Please ask for: Ms Iqraa Malik
Email: iqraa.malik@terraquest.co.uk
Telephone: 0121 234 1390
Our Ref: FP/212/21/HH
Your Ref:
Date: 5th October 2021

Application for Planning Permission for Works or Extension to a Dwelling

Development: Front ramp
Location: 9 Ramillies Gardens Felpham PO22 7QH

Block Plan shows area bounded by: 496270.02, 99975.94 496360.02, 100065.94 (at a scale of 1:500), OSGridRef: SU9631 2. The representation of a road, track or path is no evidence of a right of way. The representation of features as lines is no evidence of a property boundary.

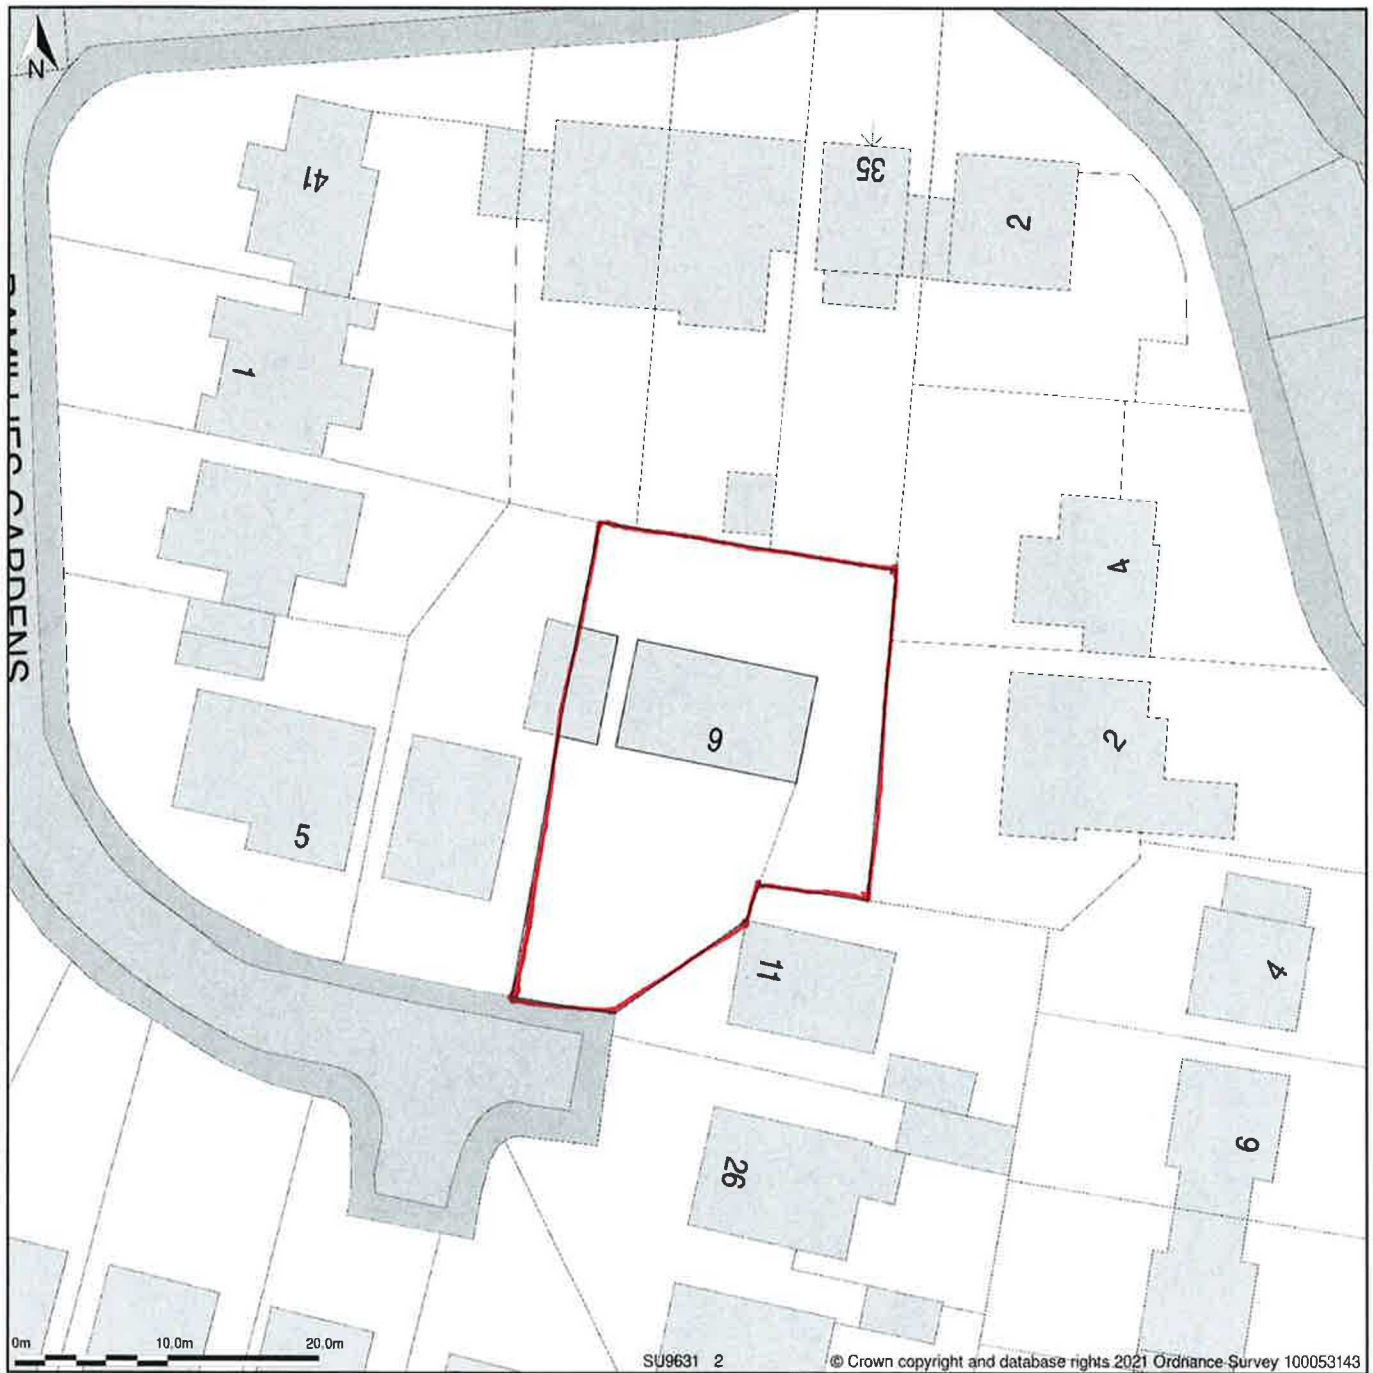
The location and block plans require one solid red outline around the site boundary. The current plans have three outlines. Please amend. Further details of what must be included on the plan can be found in the Validation Requirements List.

Drawing Title Existing Front Access Elevations

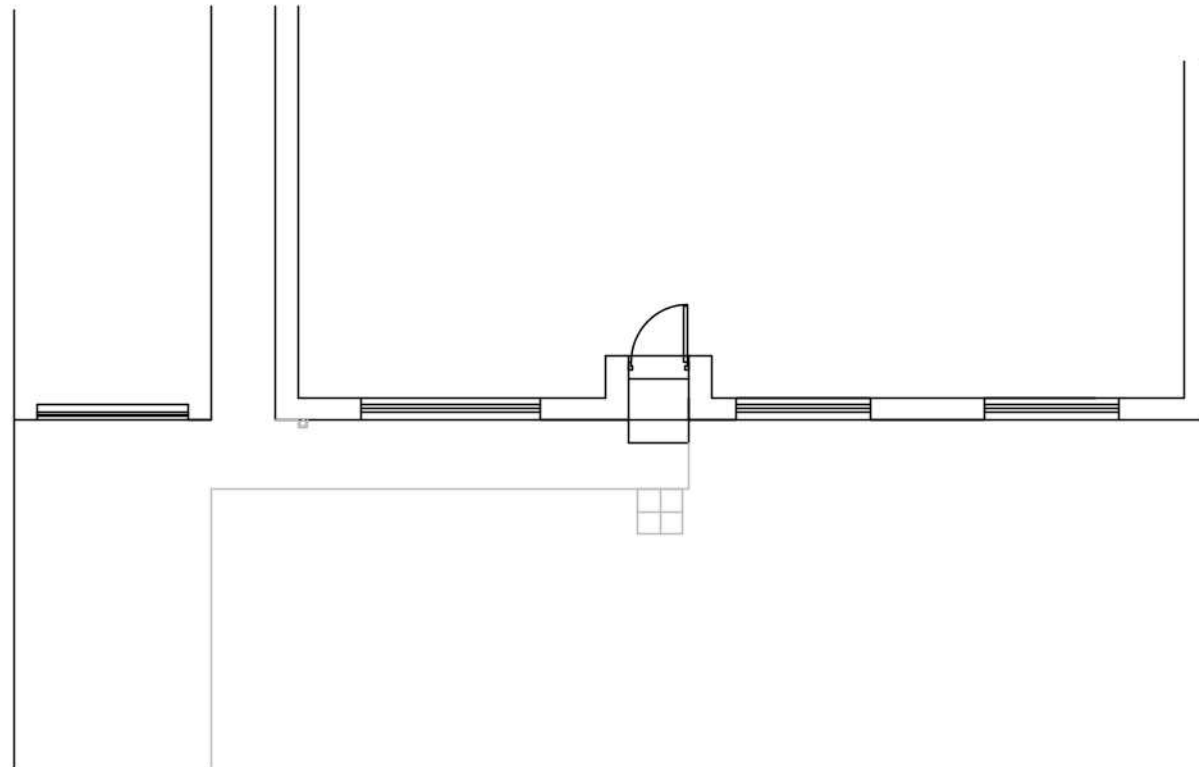
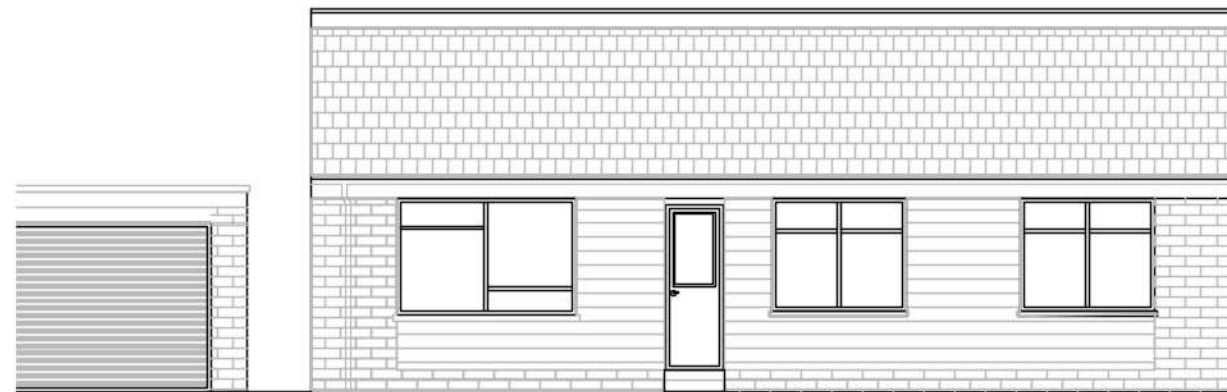
Please submit existing elevations at a scale of 1:50 or 1:100. Further details can be found in the Validation Requirements List.
